<b>Application Ref:</b>	3/2025/0755			 <b>Ribble Valley Borough Council</b> <a href="http://www.ribblevalley.gov.uk">www.ribblevalley.gov.uk</a>				
<b>Date Inspected:</b>	10/01/2025 (previous application)	<b>Site Notice:</b>	08/01/2026					
<b>Officer:</b>	MC							
<b>DELEGATED ITEM FILE REPORT:</b>					<b>APPROVAL</b>

<b>Development Description:</b>	Proposed garage for the storage of vintage tractors and cars, extension to hardstanding and change of use of land to residential curtilage.
<b>Site Address/Location:</b>	Myre Fold House, Longsight Road, Clayton-Le-Dale, BB2 7JA

Client Mr J Garnett		
Project Proposed Building at Myre Fold House Longsight Road Clayton-Le-Dale BB2 7JA		
Drawing Title Proposed Plans and Elevations		
Scale 1:100 @ A2	Date Aug 2025	Drawn LFR
READ DESIGN LTD		
172 - 02 B

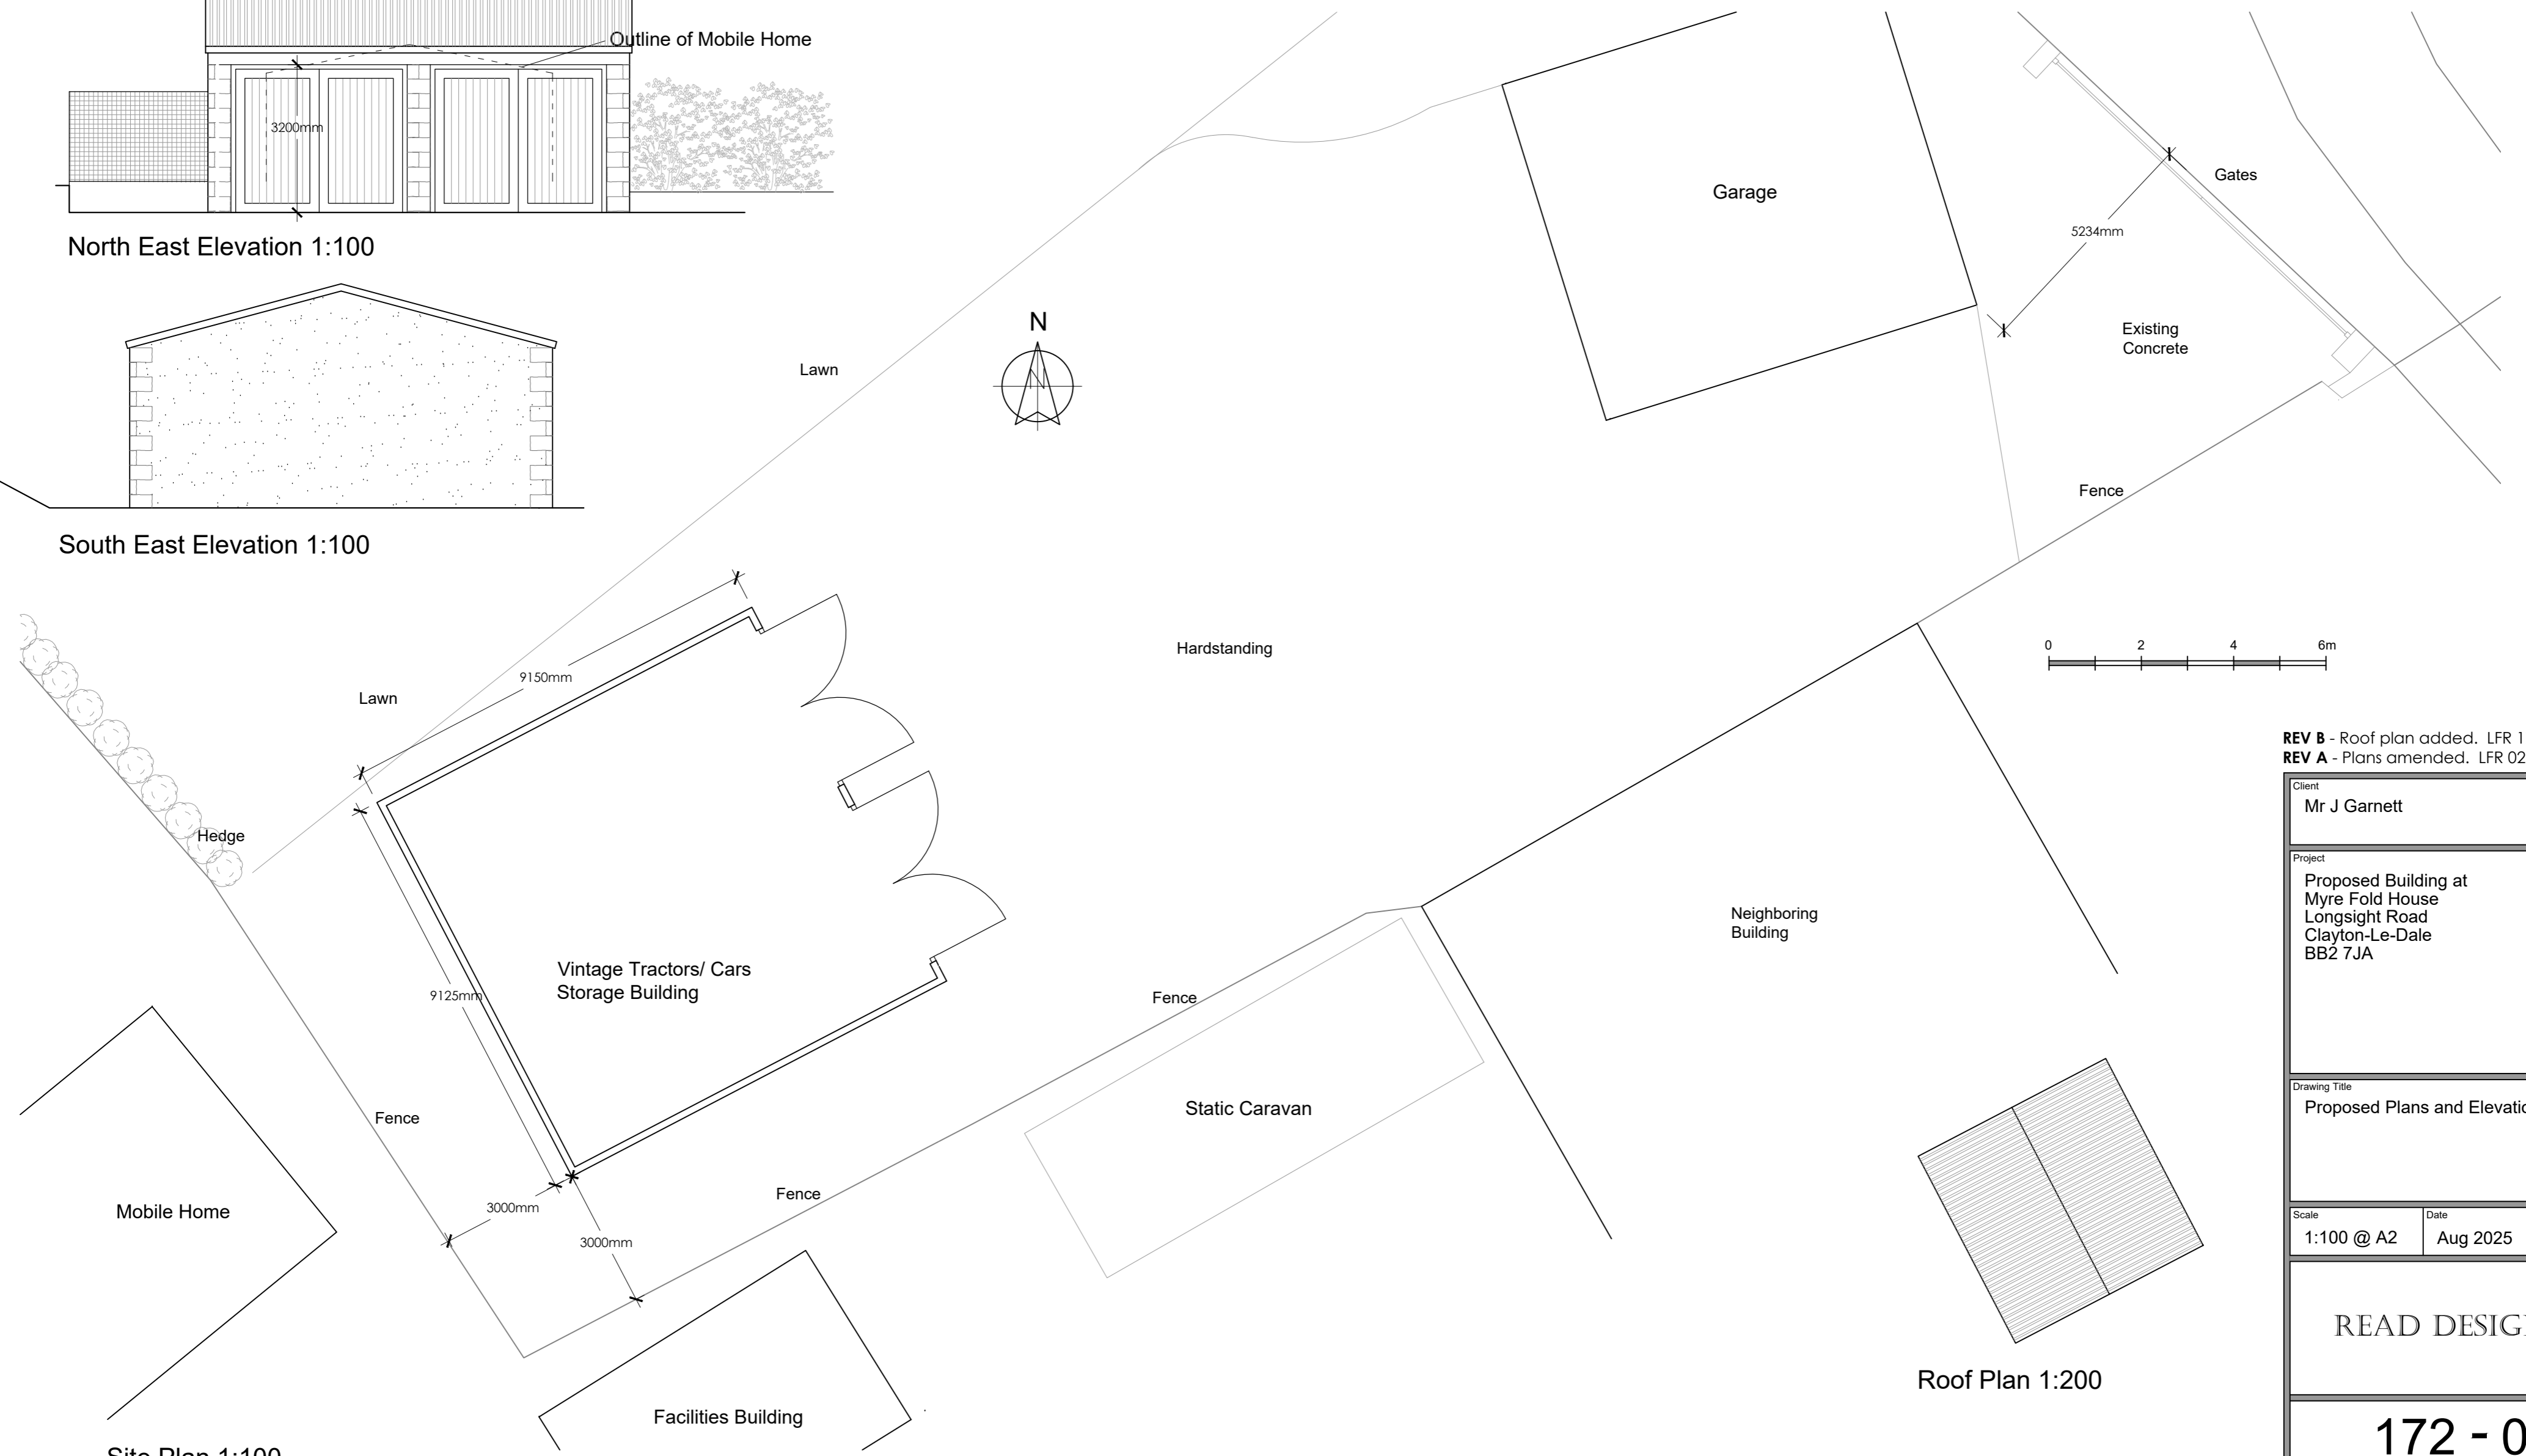
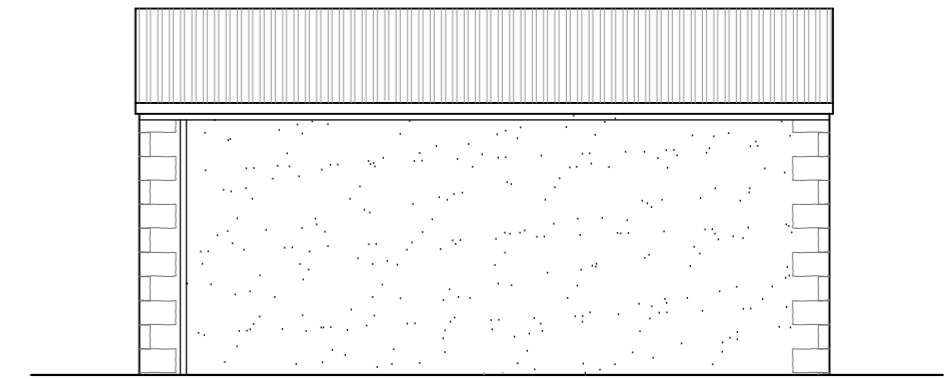
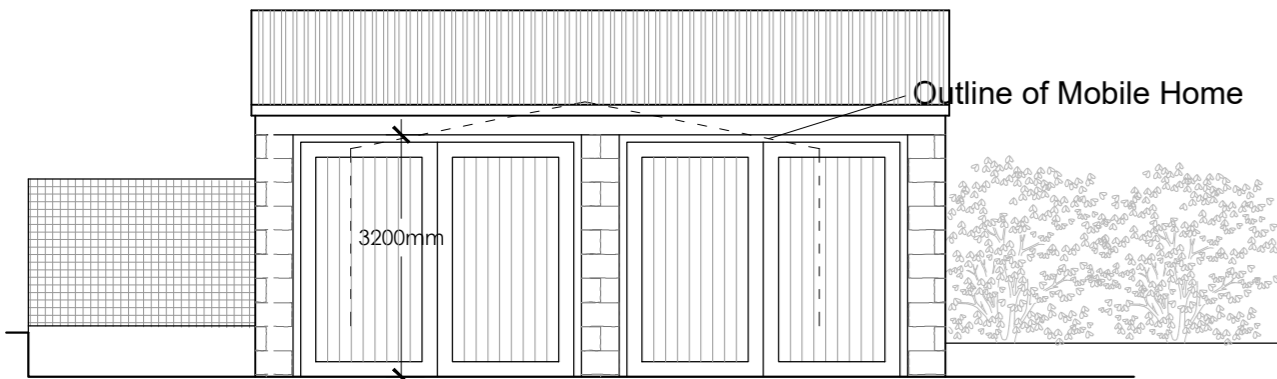
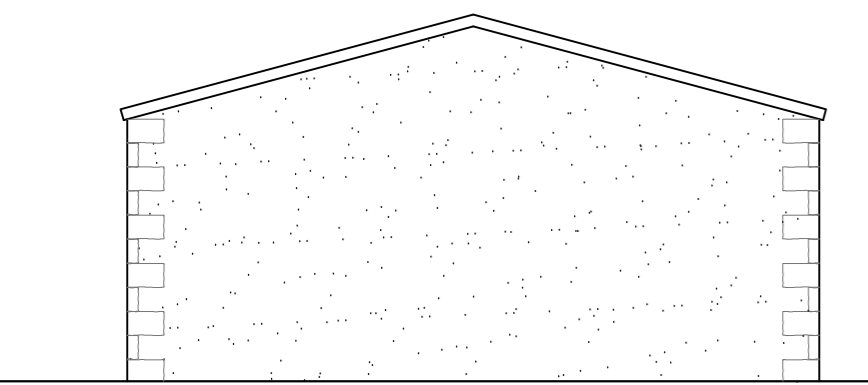
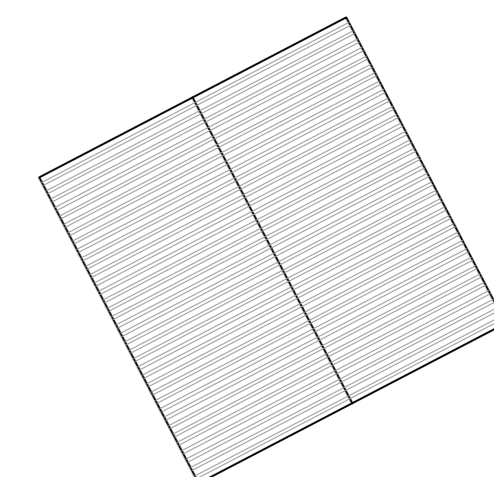
The proposed development is for a garage building to store vintage tractors and cars for hobby purposes. The proposed building measures 9.125m by 9.15m with a footprint of 83.5m<sup>2</sup>. The building would have an eaves height of approximately 3.45m and a total height of approximately 4.845m and would be constructed in natural stone and render with a profile metal sheet roof. Access into the building is via a pair of double timber doors. The proposed building would be located in the south-western corner of the site, approximately 3m from the western site boundary and approximately 3m from the southern site boundary.

An updated site plan has been provided which shows a static caravan located approximately 3.6m to the southeast of the proposed building and another mobile home located approximately 5.1m to the west of the proposed building. The proposed building would be at a minimum 3 metres from the boundary where the lodges/caravans are located. As such, due to the orientation of the dwelling and the siting of the dwelling on lower land levels at the adjacent site, the proposal is not considered to result in any adverse loss of light, overshadowing or overbearing impact, in accordance with Policy DMG1 of the Ribble Valley Core Strategy.

The proposed building has been reduced in height when compared to the previously refused agricultural building. The building would now have an eaves height of approximately 3.45m rather than 3.85m and 4.85m in height when compared to the refused scheme which was approximately 5.4m in height. The garage would also now be brought in further from the site edges and would be more domestic in appearance, being constructed of stone and render with timber doors to the front elevation rather than the refused agricultural style building which was not considered to be in keeping with the residential character of the site.

Whilst the footprint of the building is quite large still, the overall scale and appearance is considered to be an improvement on the previous scheme and would be similar in appearance to the existing garage at the site. As such, the proposed garage would be read better in context with the existing dwelling compared to the refused agricultural barn. In addition, the building is not considered to be significantly prominent or incongruous within the landscape due to its proposed materials and lower eaves height.
